SICEEP The Haymarket Concept Proposal - Response to Public Submissions

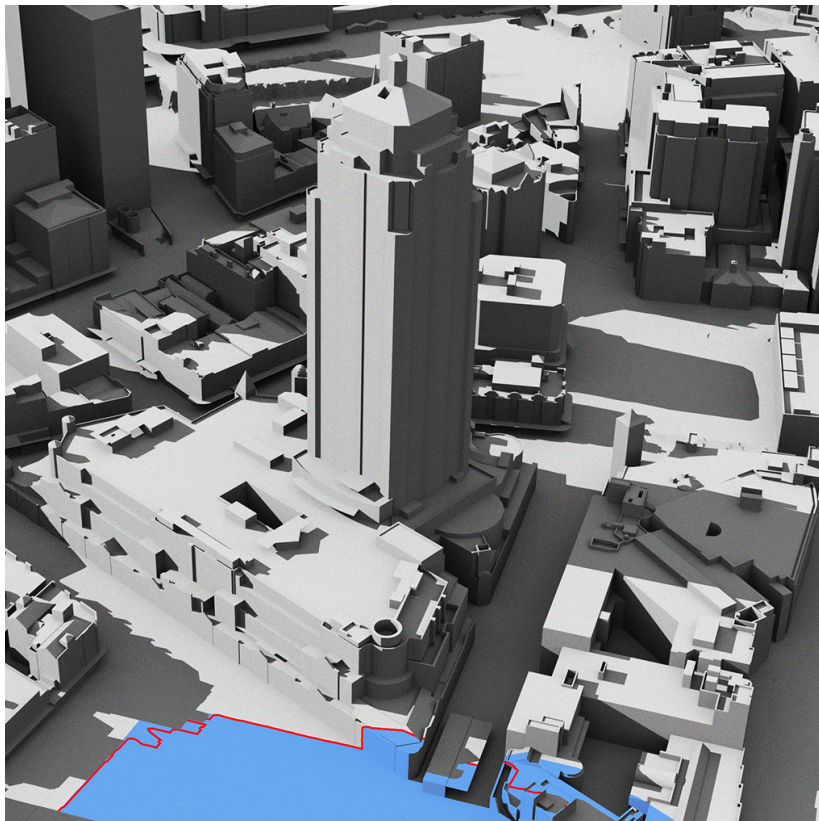
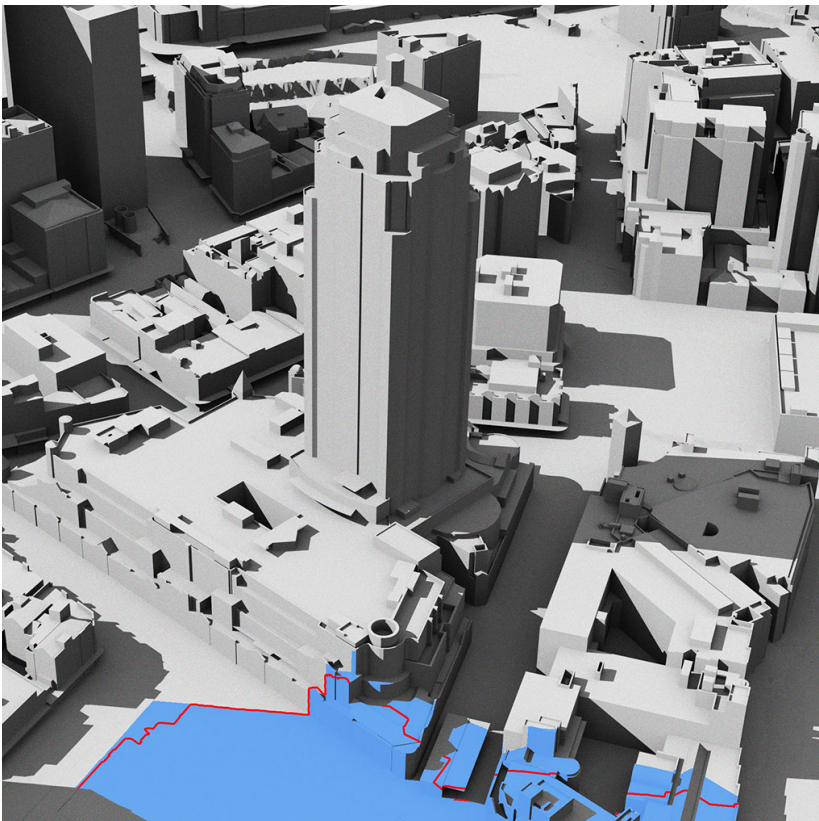
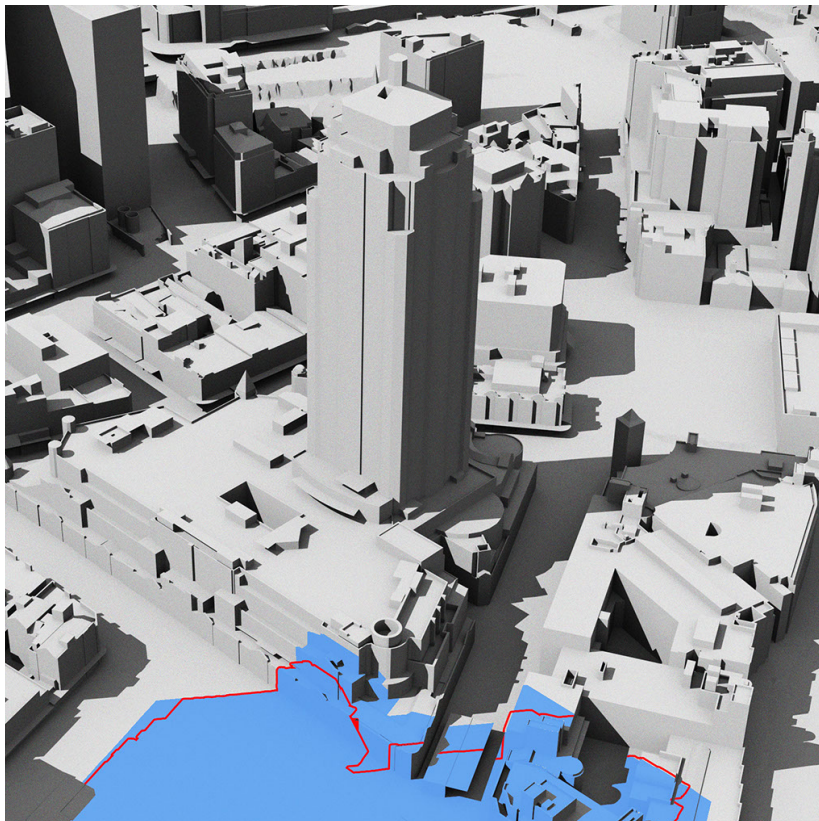
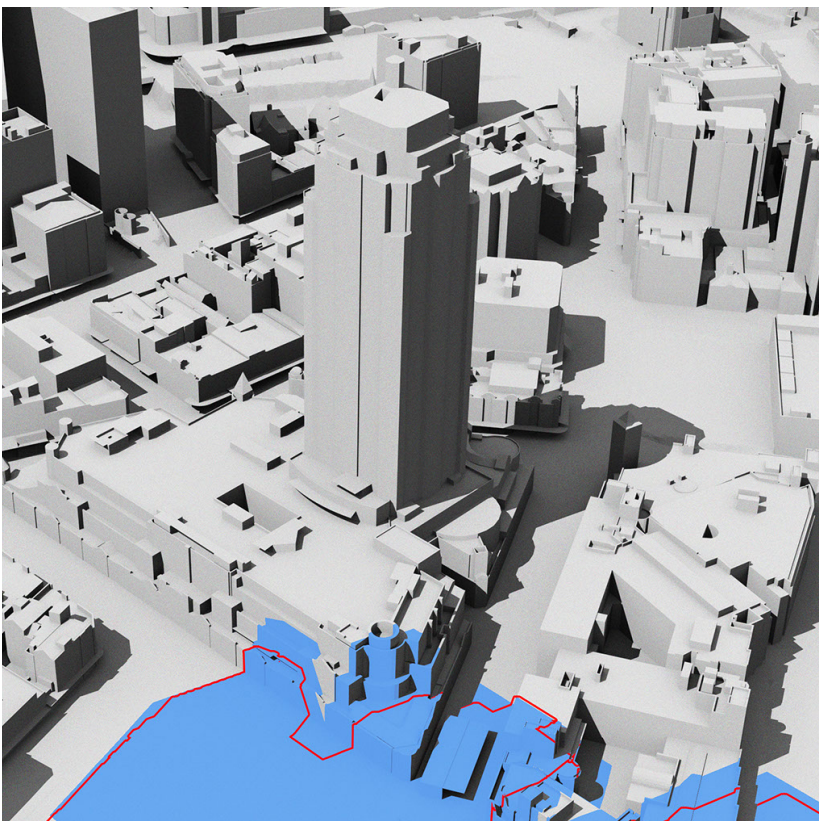
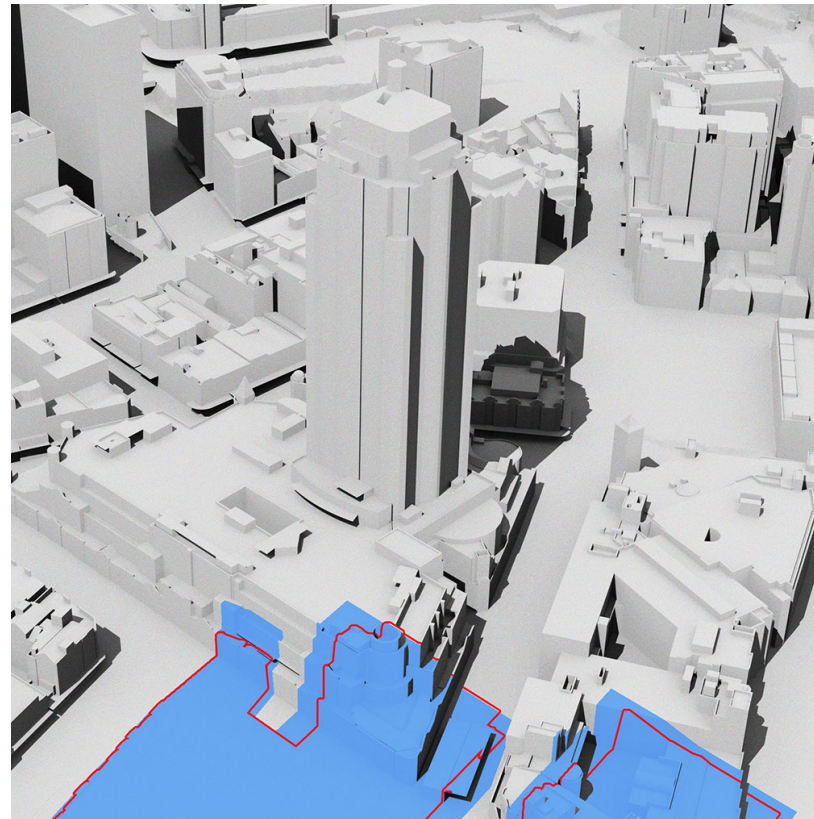
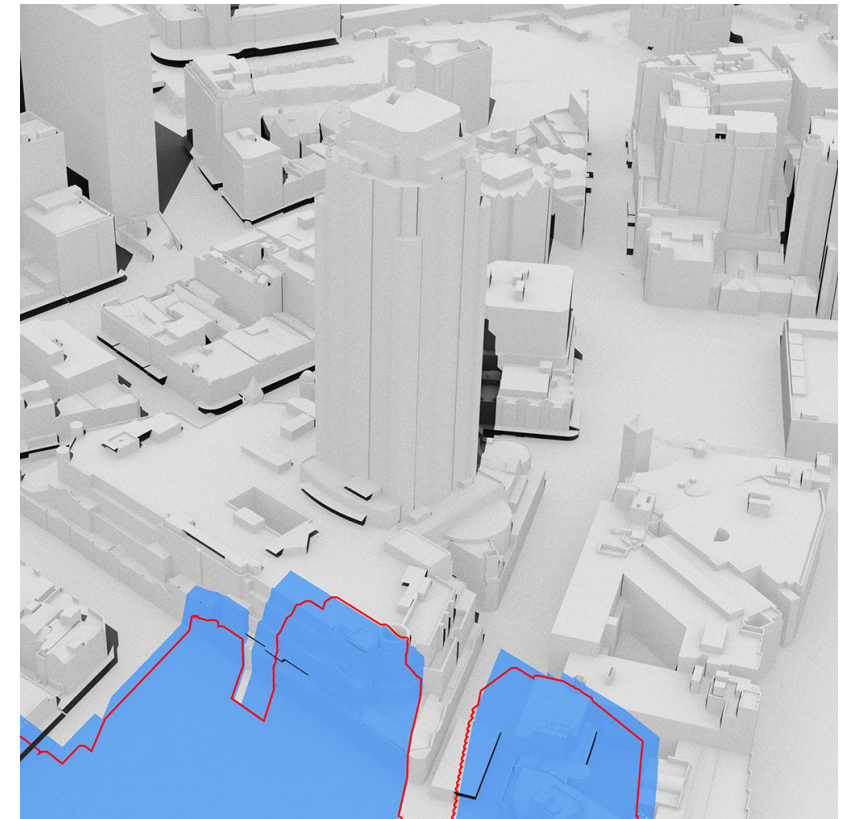
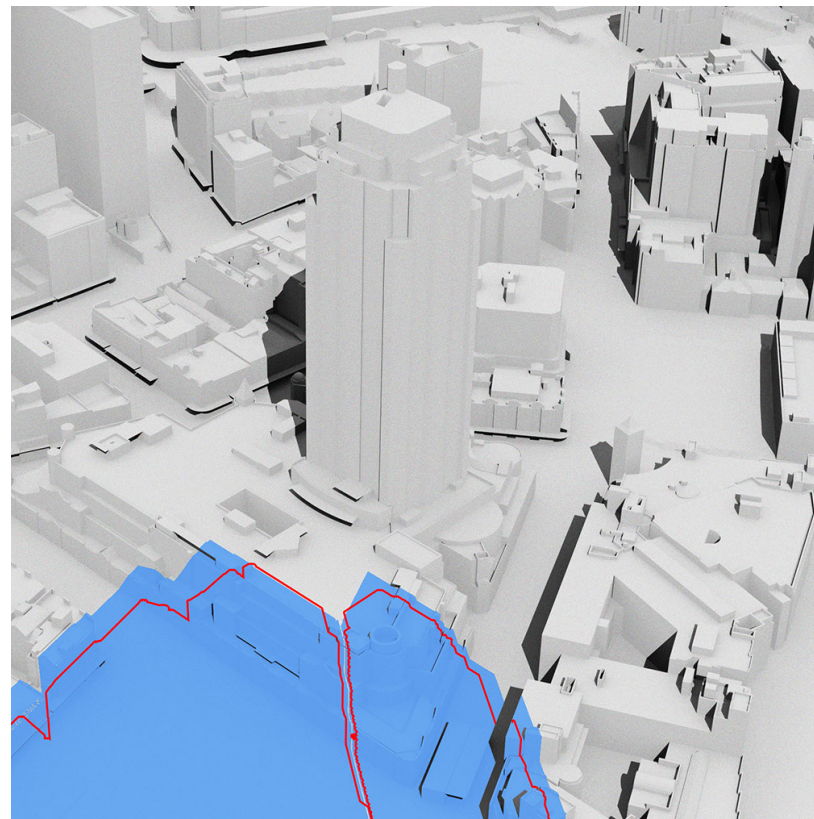
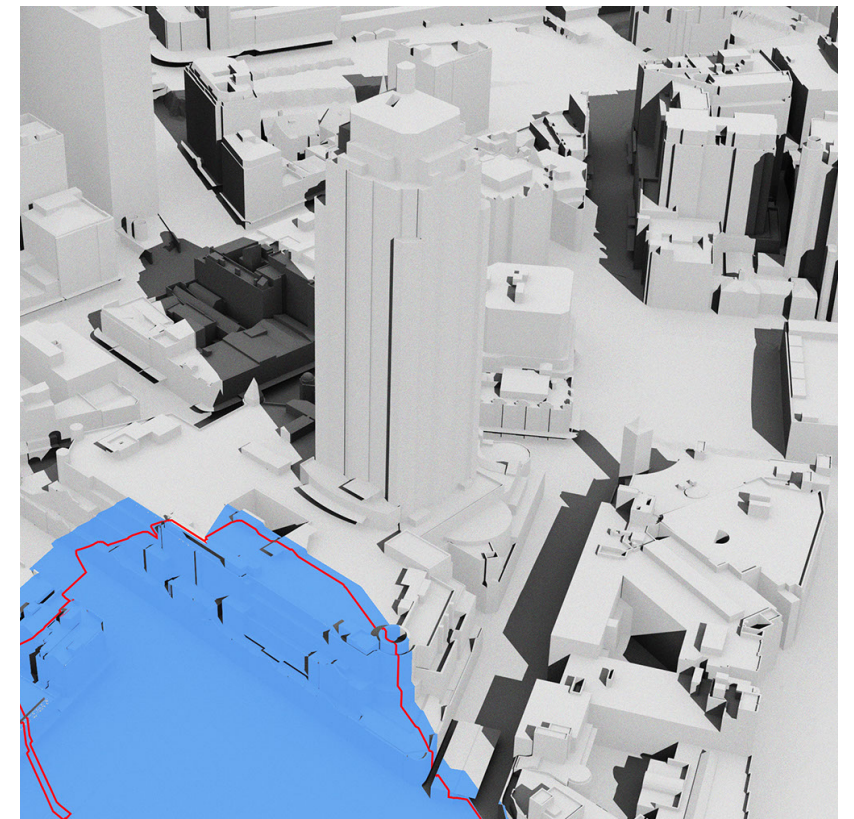
34	The EIS says nothing about overshadowing The Quay apartments.	<p>Revised shadow studies have been prepared and are included in the Supplementary Design Report (refer to Appendix H). The studies indicate that The Quay Apartments will not be subject to overshadowing as a result of the proposed building</p>
